From: Tom Callaway [REDACTED]
Sent: 26 September 2014 10:03
To: Peter Cleveland
Subject: FW: Oldlands - Hanbury (nos. 3 & 6) and Bericote (no. 3) conditions

In Tom's absence are you able to have a look at the attached and confirm whether or not I am able to discharge Conditions 3 and 6 of BE/61/13, the only outstanding information was the detail of this headwall and the treatment of the ditch as per the emails sets out below.

CONTENTS	
Identifier	Name
Hydrock	Drawing No. C14443/502

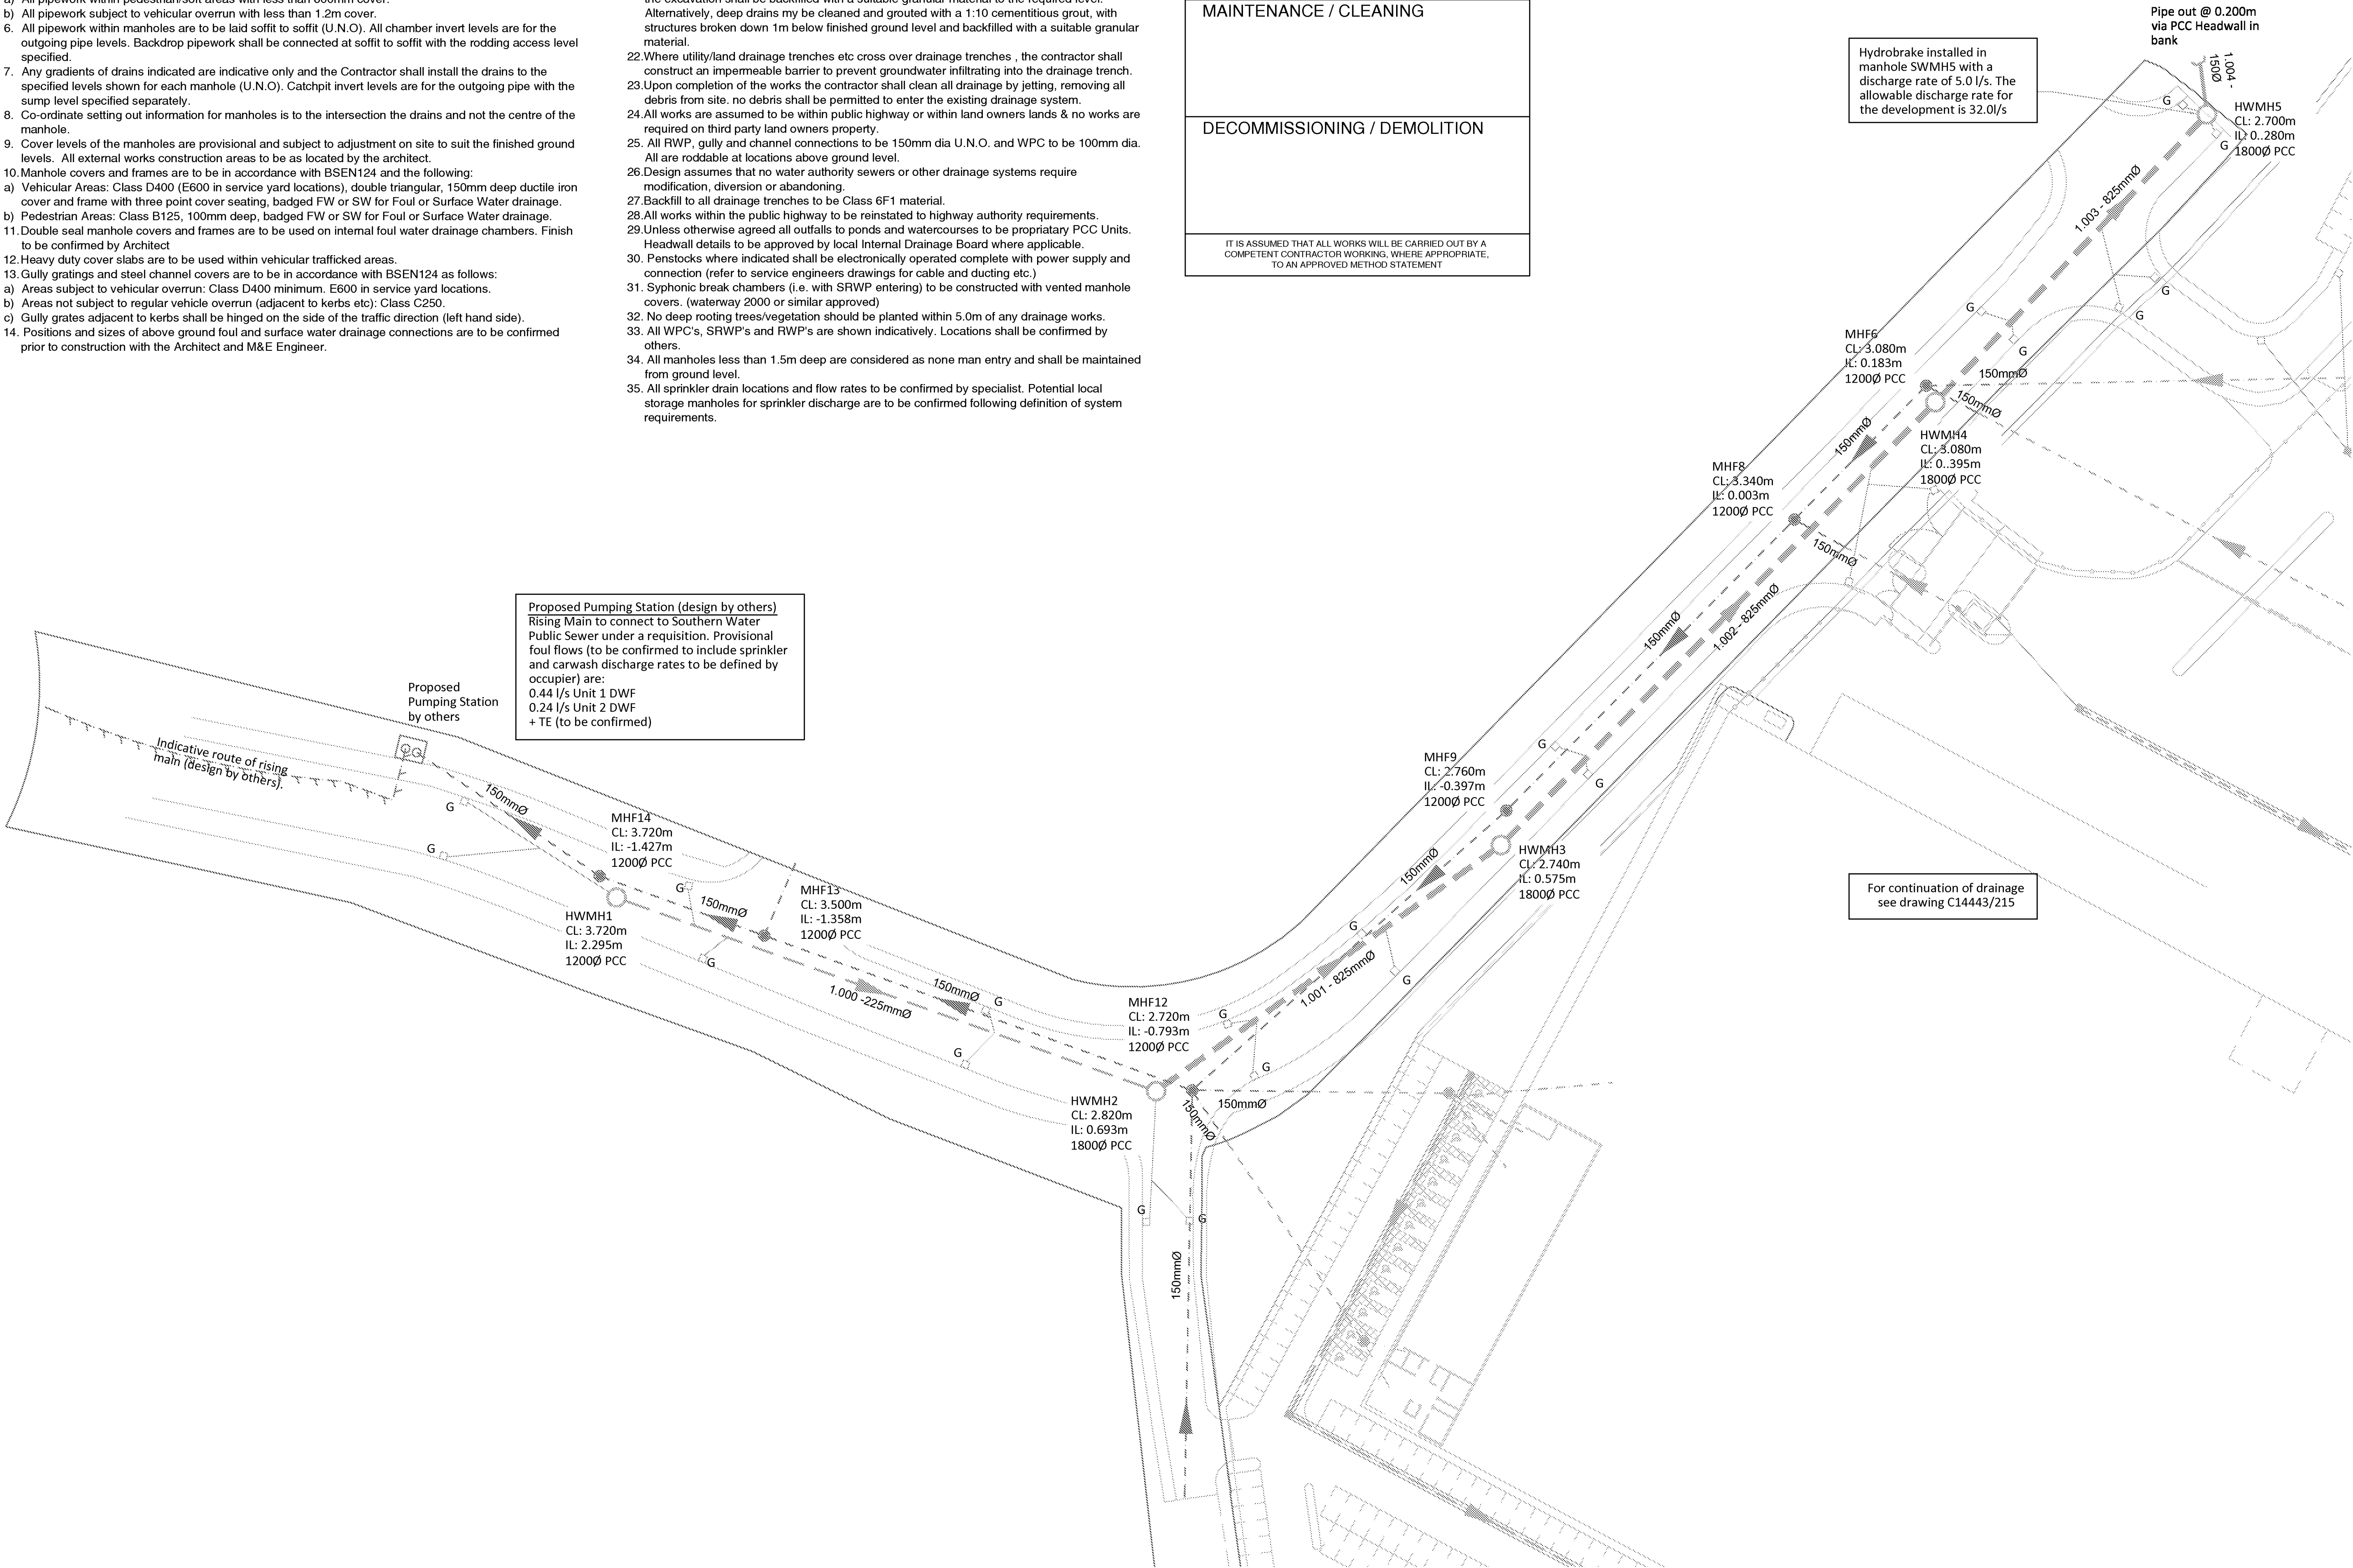
It forms a part of the drainage design which our engineers require for completeness. As the drainage discharges to a ditch, they want to be sure that the condition of the ditch is suitable to accommodate the discharge, because as noted in the EA's response, its condition is unknown.

Therefore the condition may be discharged if everyone else is happy and the outlet to the ditch/headwall details can be provided

The headwall details seem fine to me. The conditions may be discharged on this basis.

The proposed headwall detail is as shown on the attached drawing (type 2). The ditch will be cleared out to ensure that flows are not obstructed. I trust that the condition can now be discharged.
